Ref: D21/25015

17 March 2021

Council's submission to SSD-10451 for the Royal Institute for Deaf and Blind Children (RIDBC) Centre of Excellence at Macquarie University campus

Figure 12 Vehicle access arrangements

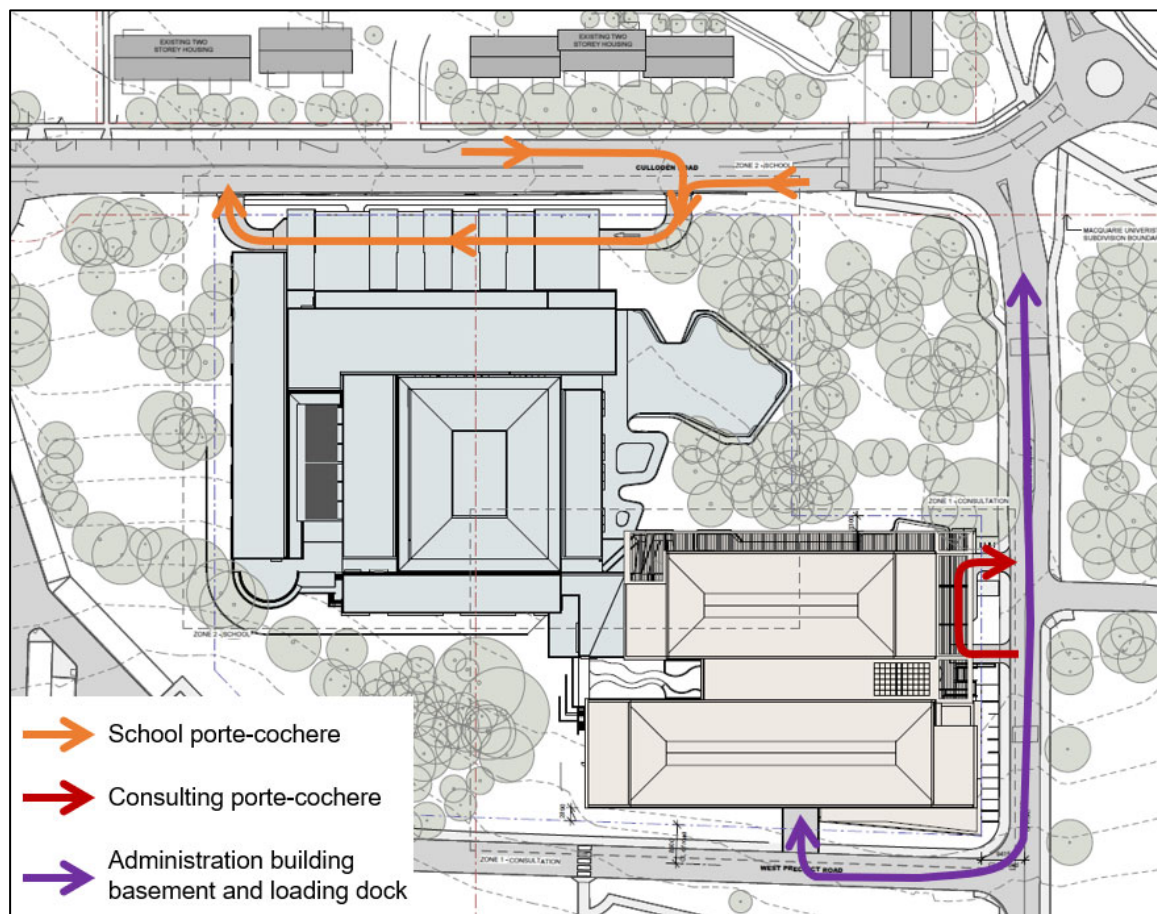
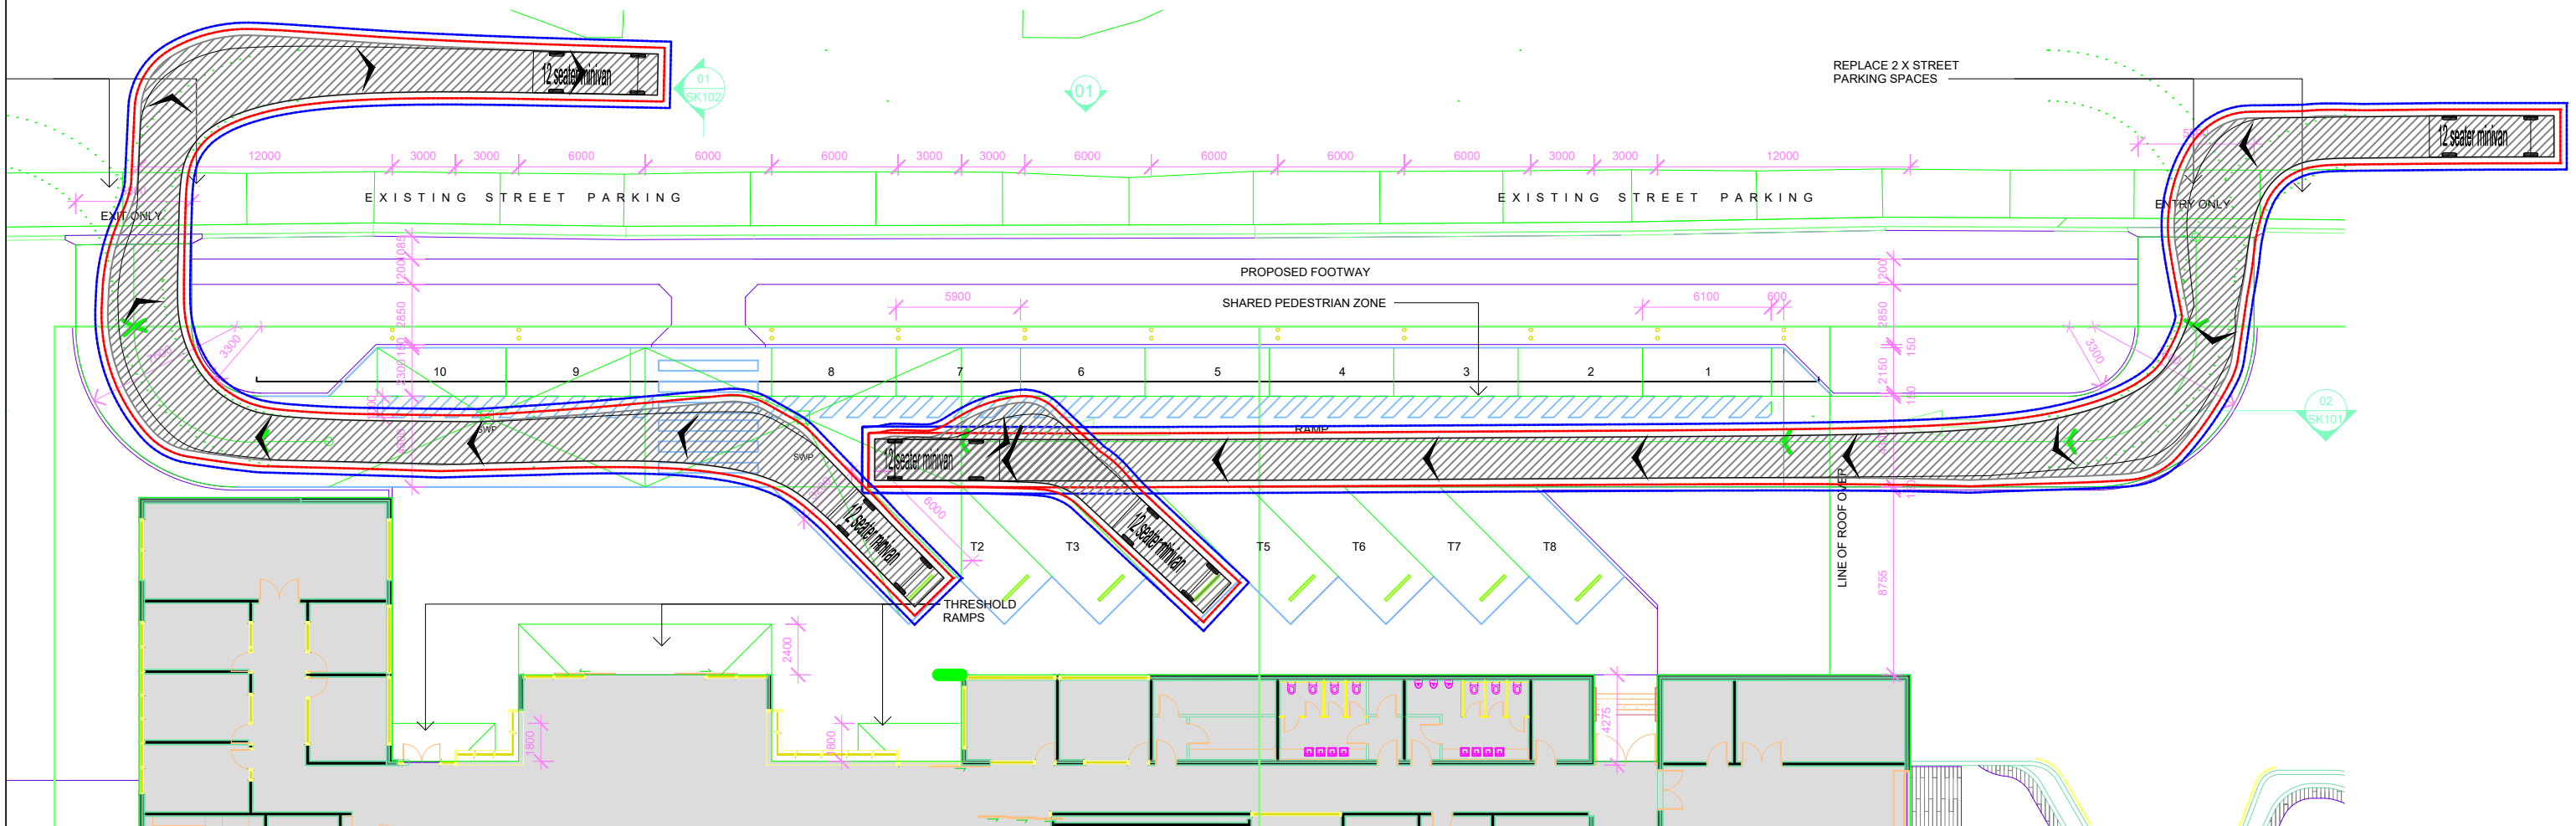
- 1) No traffic assessment has been undertaken for Culloden Road adjoining the subject site, which will be directly impacted by the proposed development;
- 2) No queuing analysis has been undertaken with respect to the student pick-up/drop-off within the porte cochere; and

- a) The off-street car parking (including the kiss and drop-off zone within the porte cochere) and heavy vehicle loading/unloading areas have been designed in accordance with the latest version of AS2890.1, AS2890.2 and AS2890.6;

- c) Swept paths demonstrating that passenger vehicles can access and vacate all parallel and angled parking spaces within the porte cochere without any issues.
